17 December 2021

**SECTION 4.55(1A) MODIFICATION APPLICATION – SSD 6966
BUILDING R5, ONE SYDNEY HARBOUR, BARANGAROO SOUTH**

This modification application has been prepared by Ethos Urban on behalf of Lendlease (Millers Point) Pty Ltd (Lendlease), pursuant to section 4.55(1A) of the *Environmental Planning and Assessment Act 1979* (EP&A Act) to modify Development Consent SSD 6966 relating to Residential Building R5 at Barangaroo South (the site).

Drawing: BR5_ASD_PA1_4002
Date: 15 DEC 2021 Revision: 22
Drawn: MT Checked: MC
SECTION 4.55

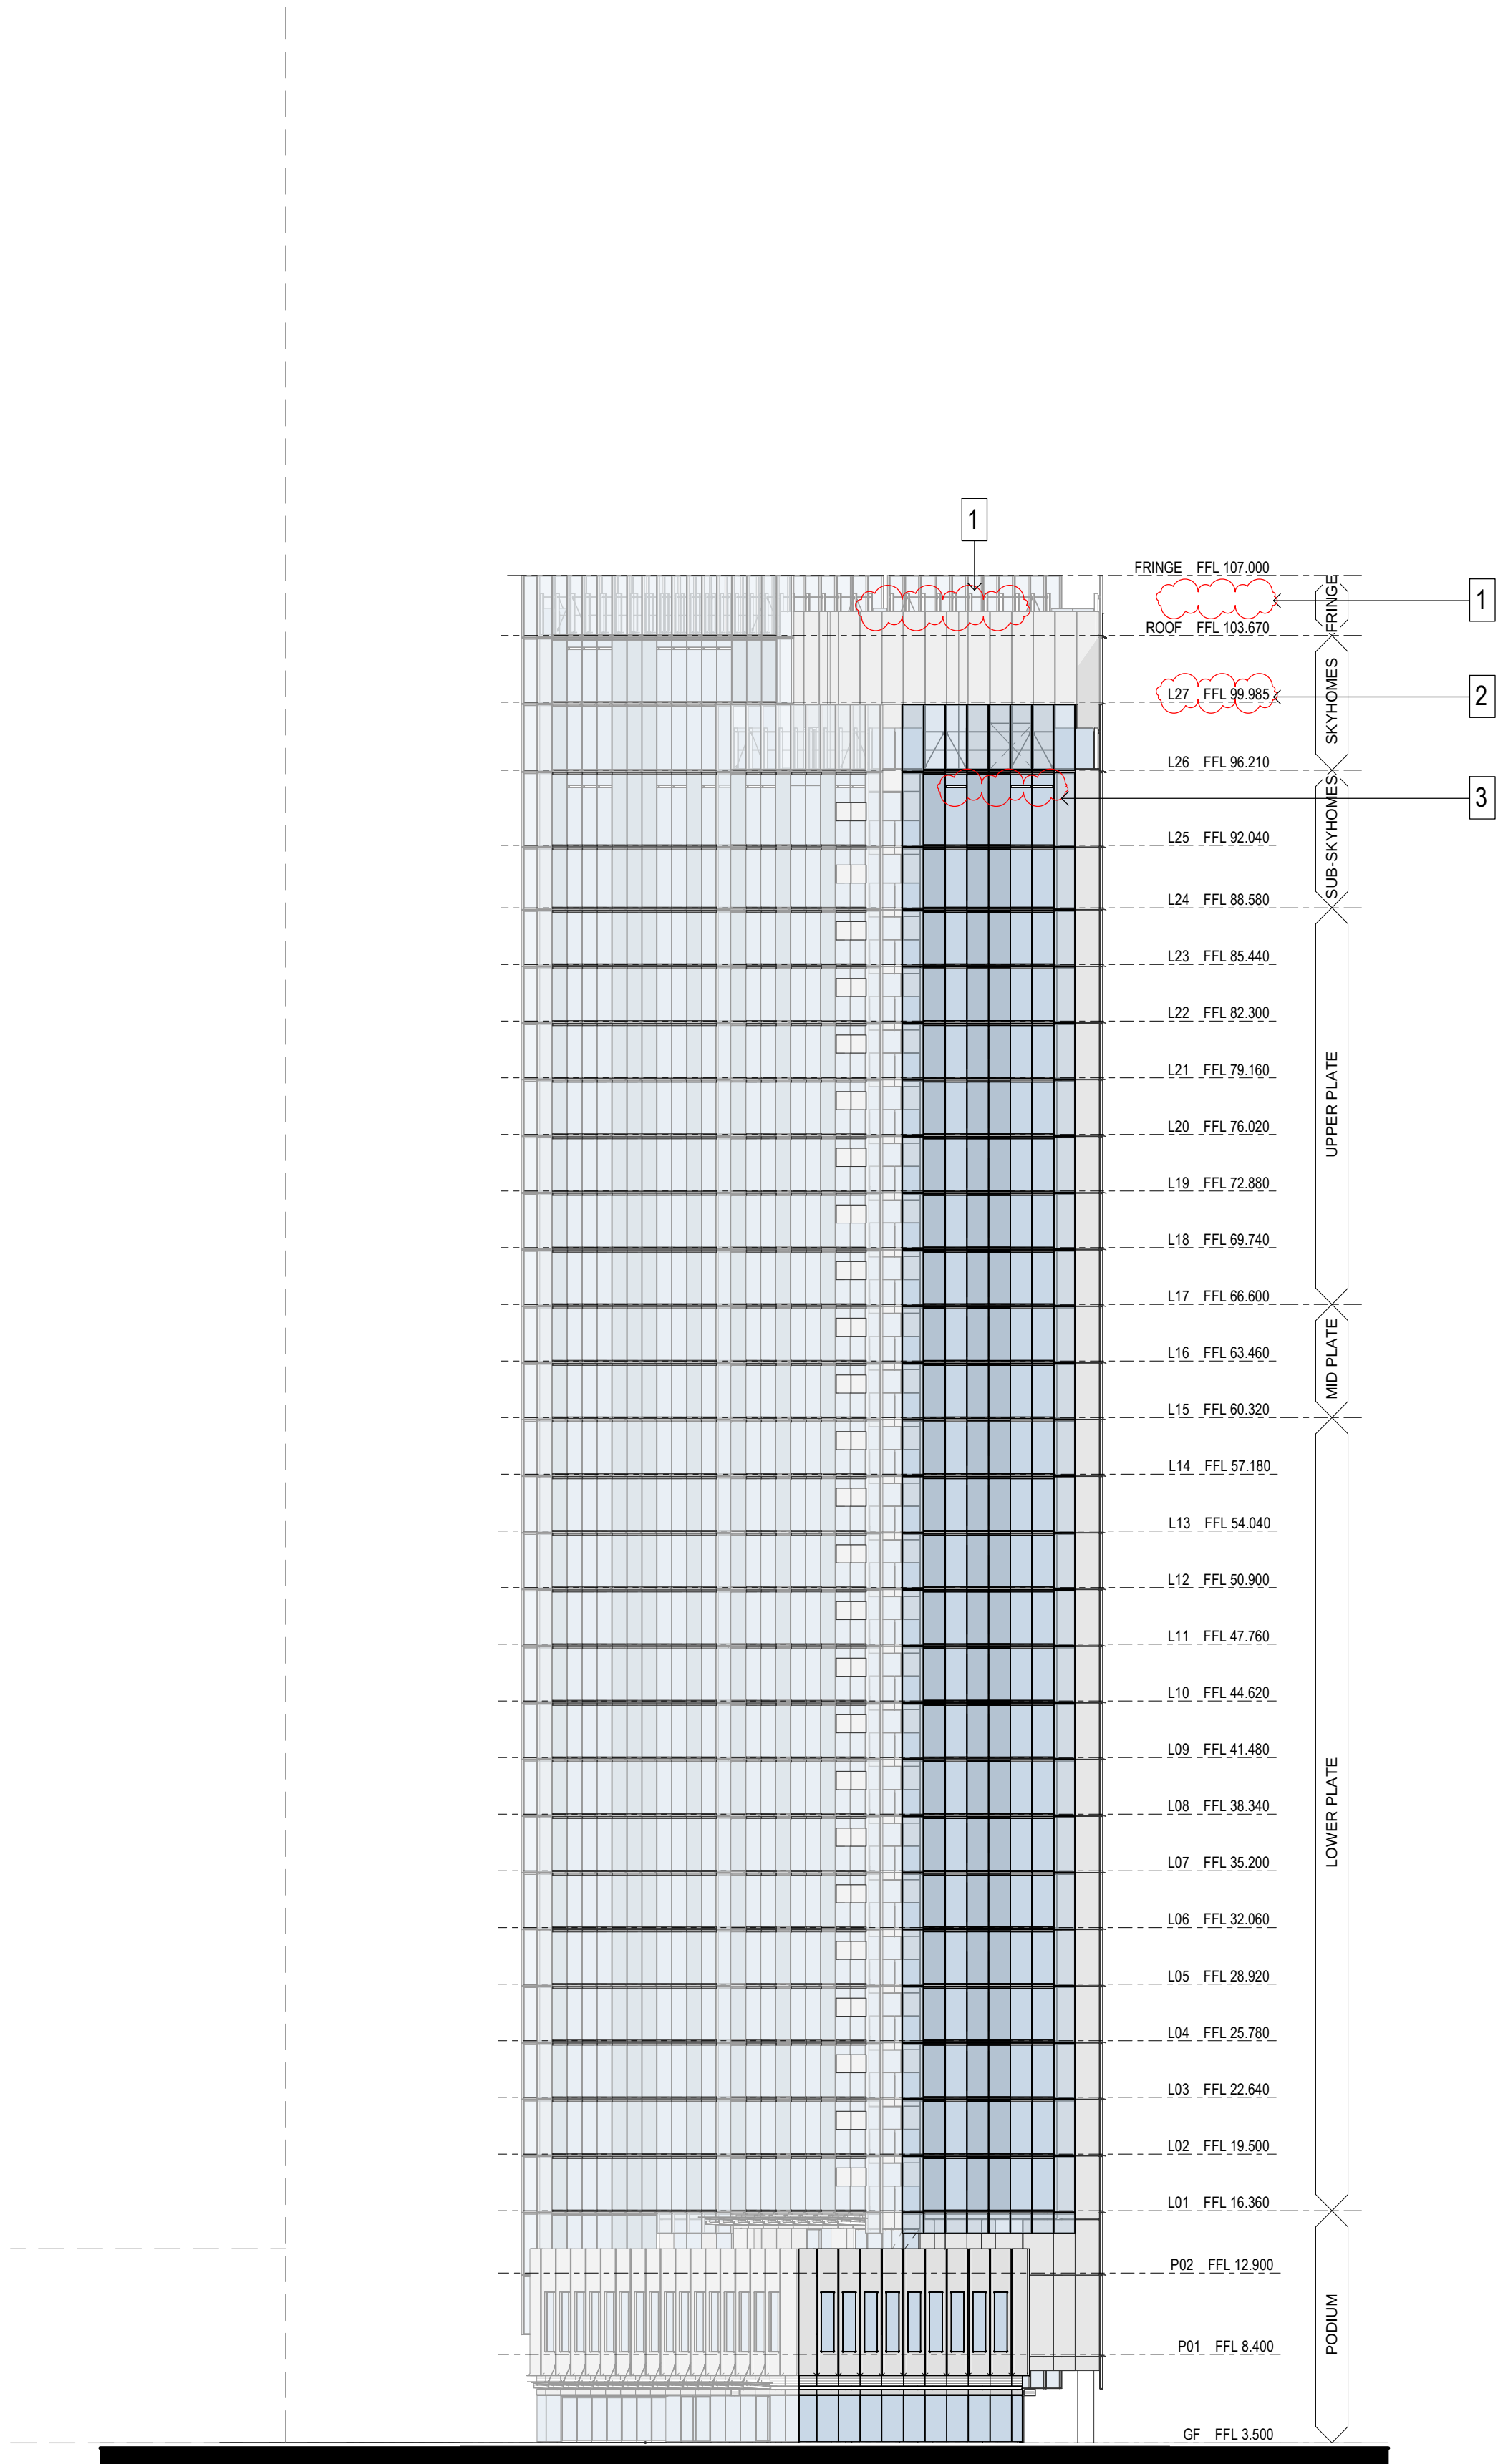
In addition to this, it is proposed to include additional ventilation slots within certain panels external to these floors, as well as on Level 1. It is noted that these slots will be consistent in design with existing ventilation slots currently incorporated into the approved façade design. The location of these additional ventilation slots can be seen below in **Figure 7** and **Figure 8**.

2.1 Amended Finish Floor Levels

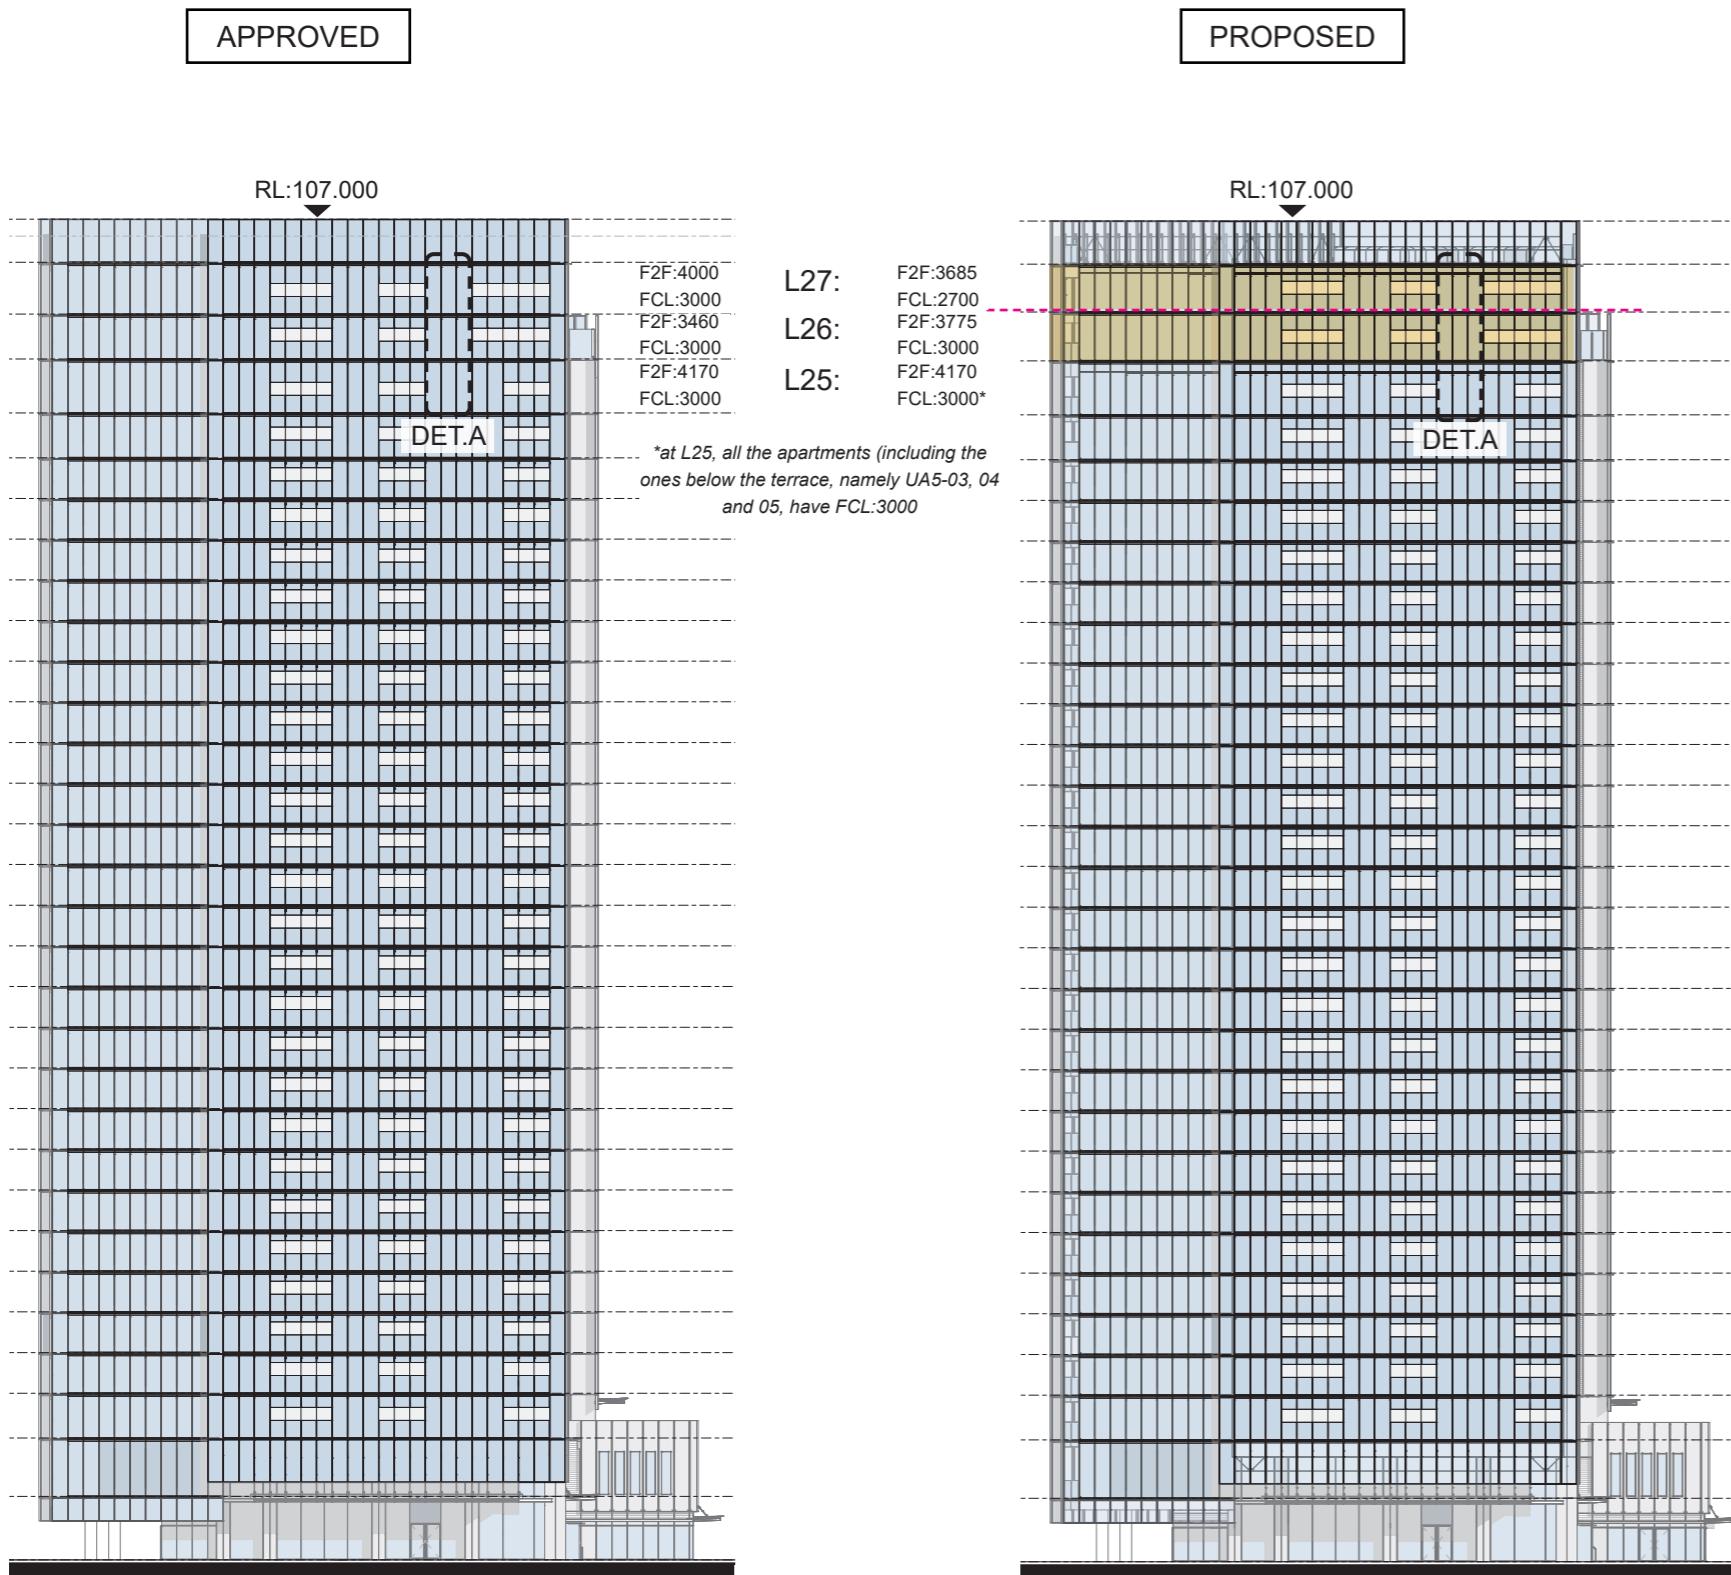
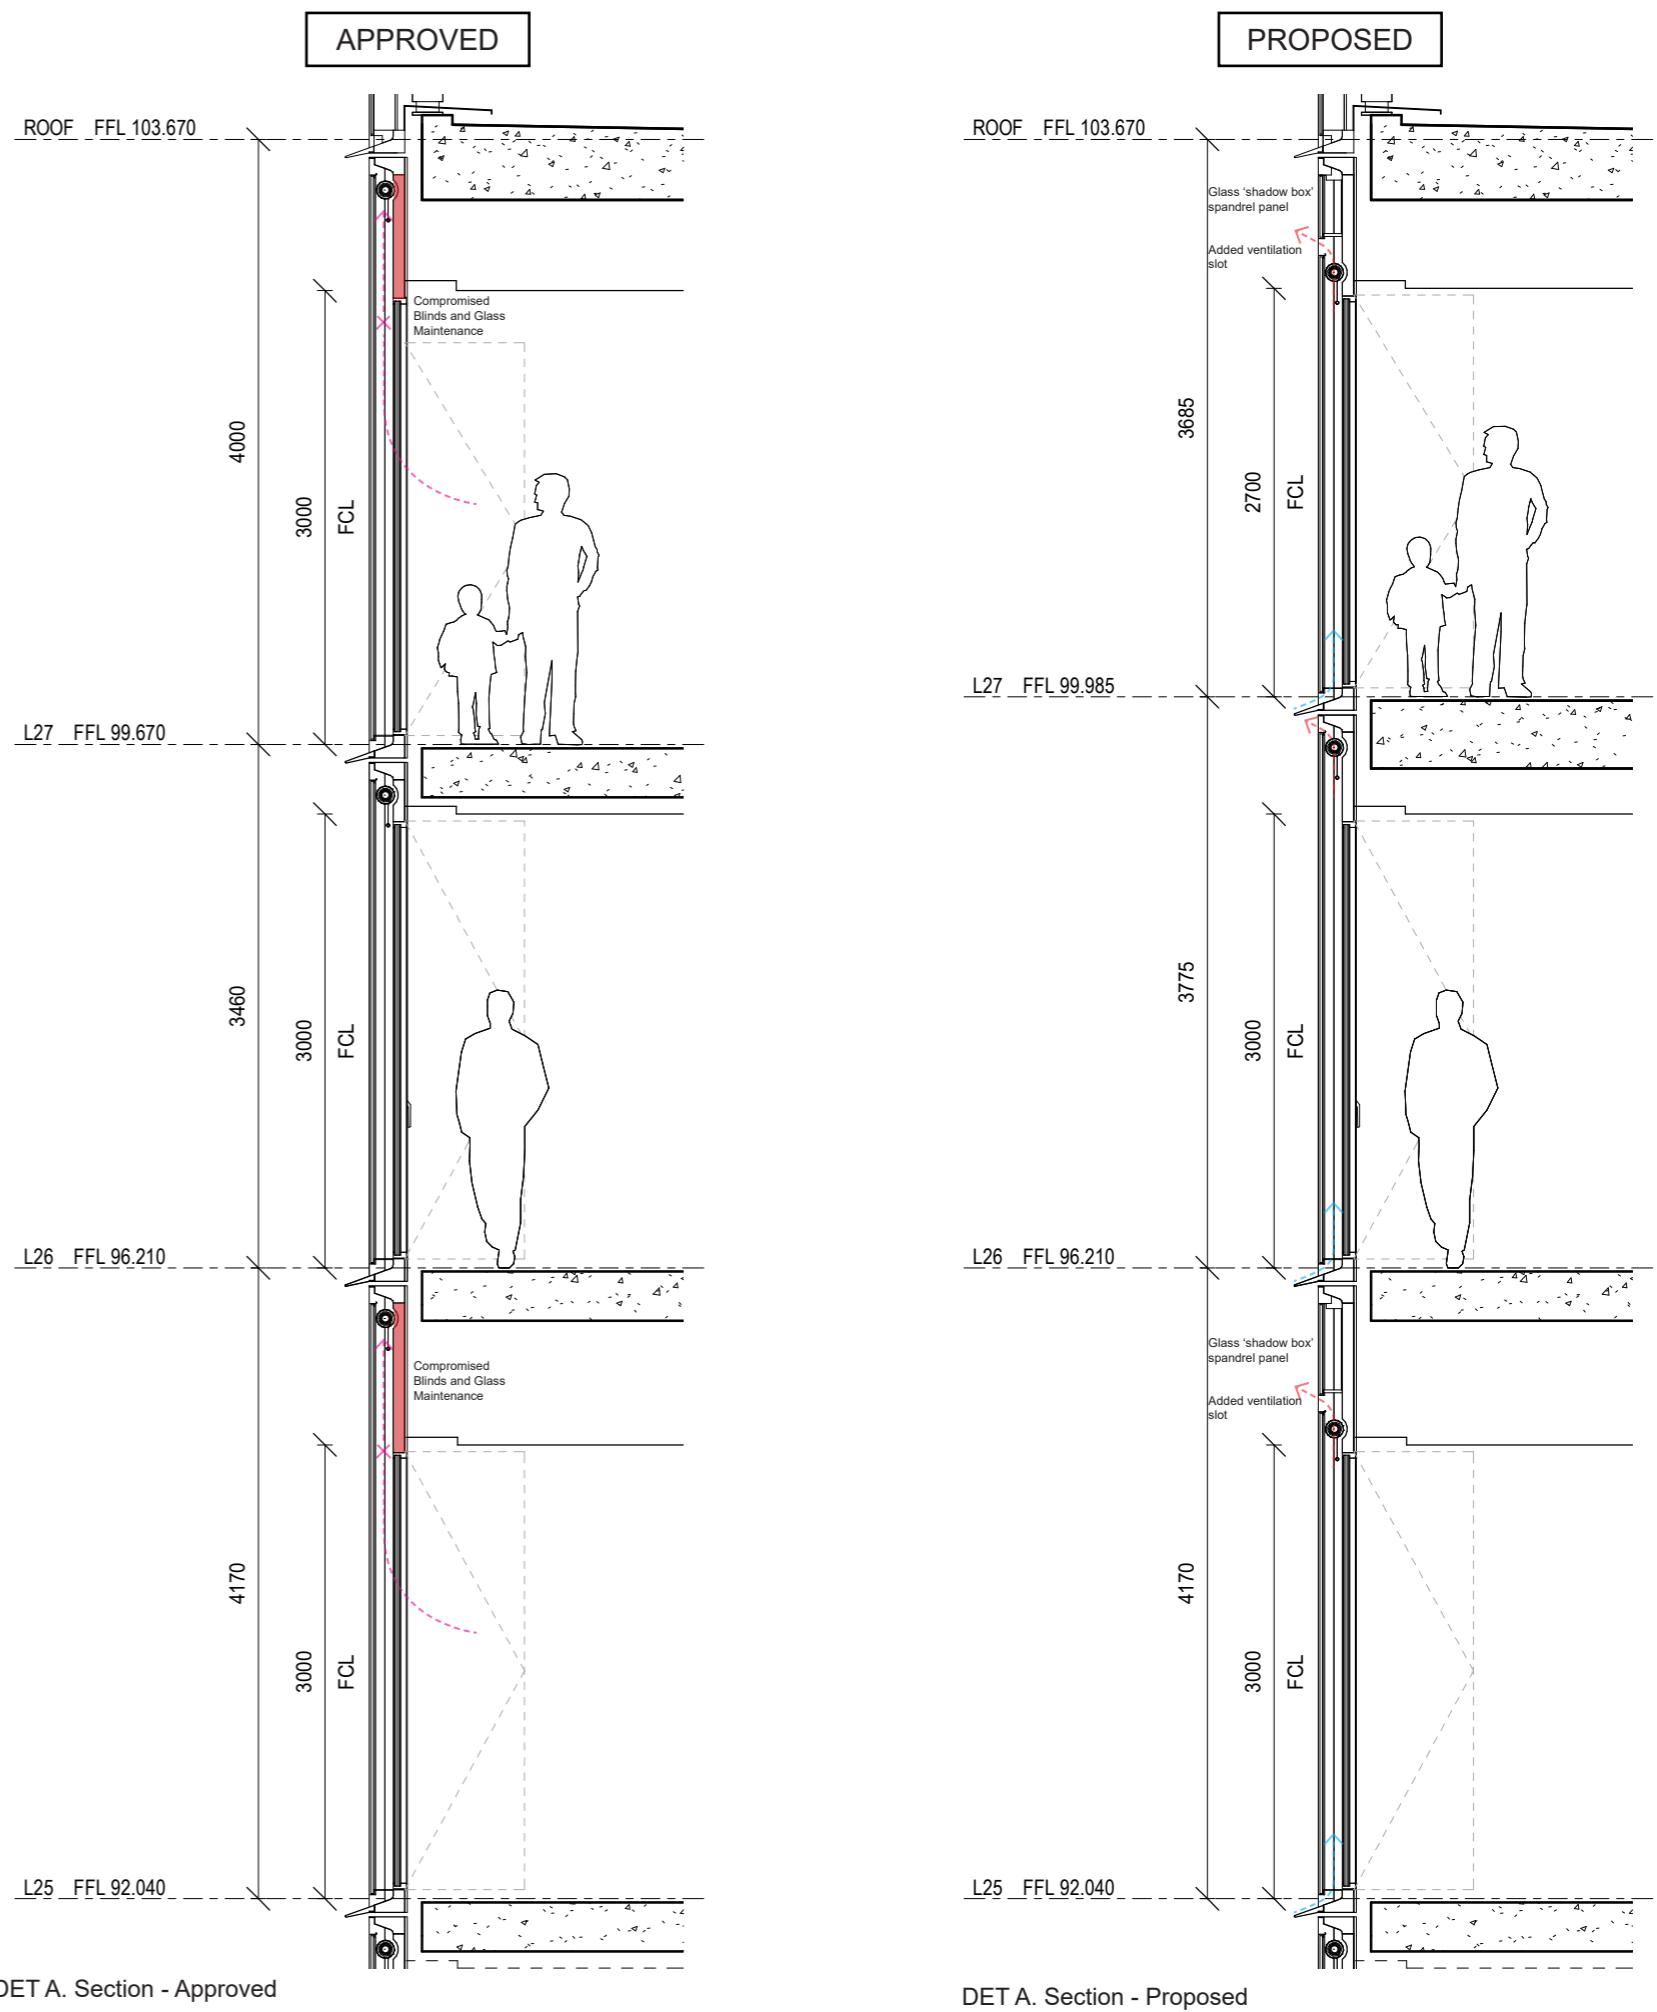
As a result of structural constraints, the desired 3m floor to ceiling height at the Level 26 ‘Skyhomes’ has not been achieved. As such, a design solution is proposed to raise the floor slab of Level 27 by 315mm, which will enable 3m floor to ceiling heights on Level 26. This will result in a subsequent reduction of the floor to ceiling height of Level 27 to 2.7 metres. As a result of these amendments to the finished floor levels, the layout of the internal OCF façade has been revised. The proposed alterations are shown below in **Figure 3** and **Figure 4**.
